27 August 2014

File No: R/2013/4/A
Our Ref: 2014/389177

RE: s96 Application for the University of Sydney Australian Institute of Nanoscience (AIN) building (SSD 5087 MOD 1)

Figure 6
Roof plan showing the proposed location for the observatory (marked with an arrow)
Source: Architectus

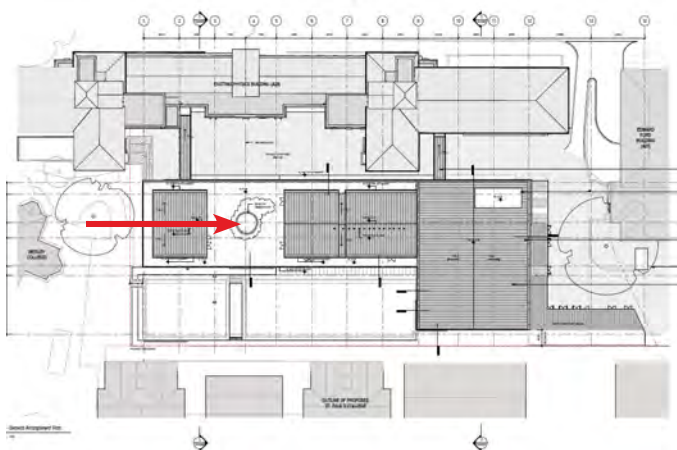
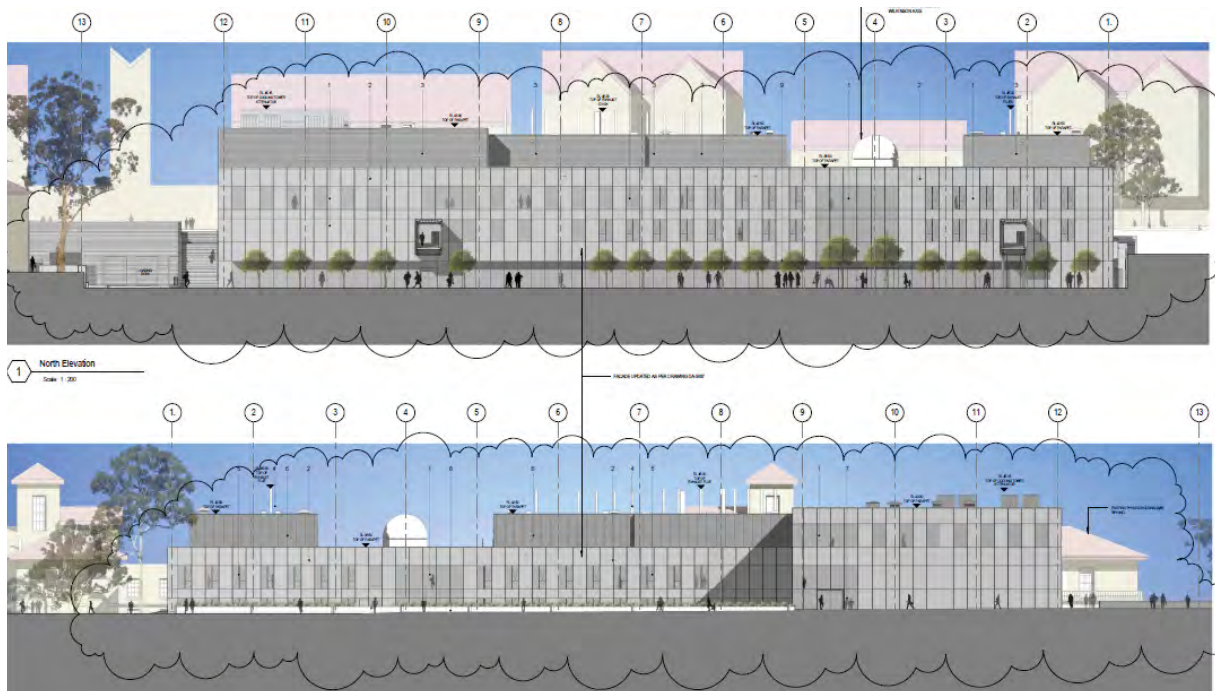
The scale of the observatory sits below the height of the flanking roof elements, and is centrally located between them to retain the important alignment with the Wilkinson axis. No objection is raised to the observatory.

Fig 1.6 Sketch of proposed entry on Southern Boundary (provided by University of Sydney Design Manager, 2014)

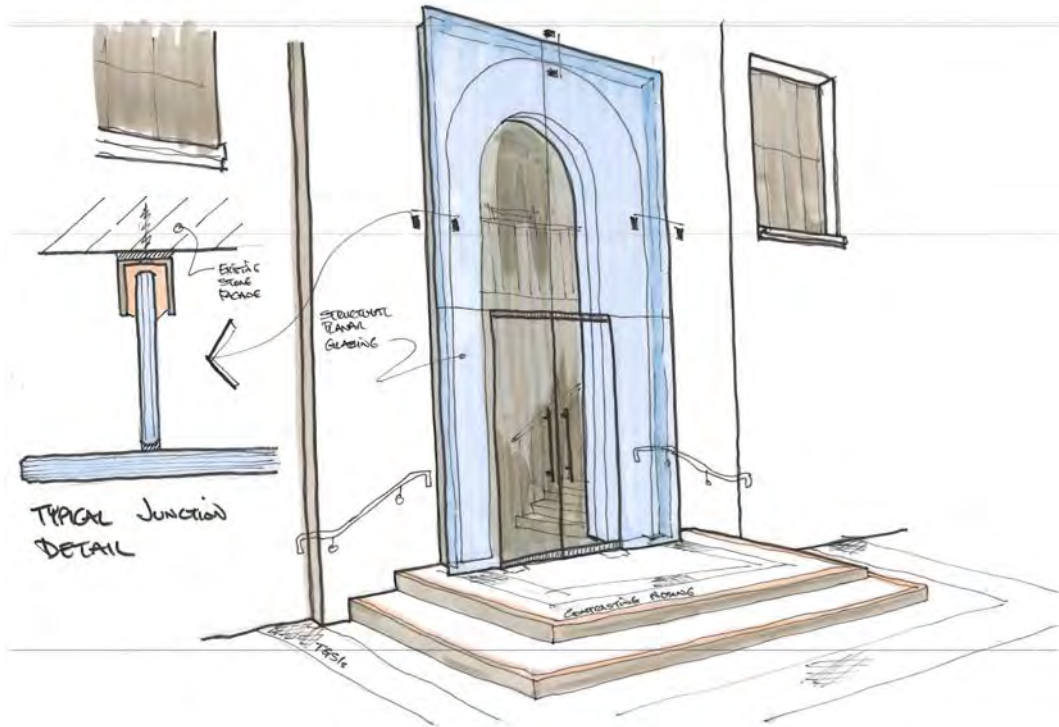
The conversion is considered minor and the design plan has been carefully considered, including the necessary detail to ensure that the existing sill is carefully removed and that the doorway retains the existing window width and detailing consistent with the remainder of the building. No objection is raised to the window conversion to a door.
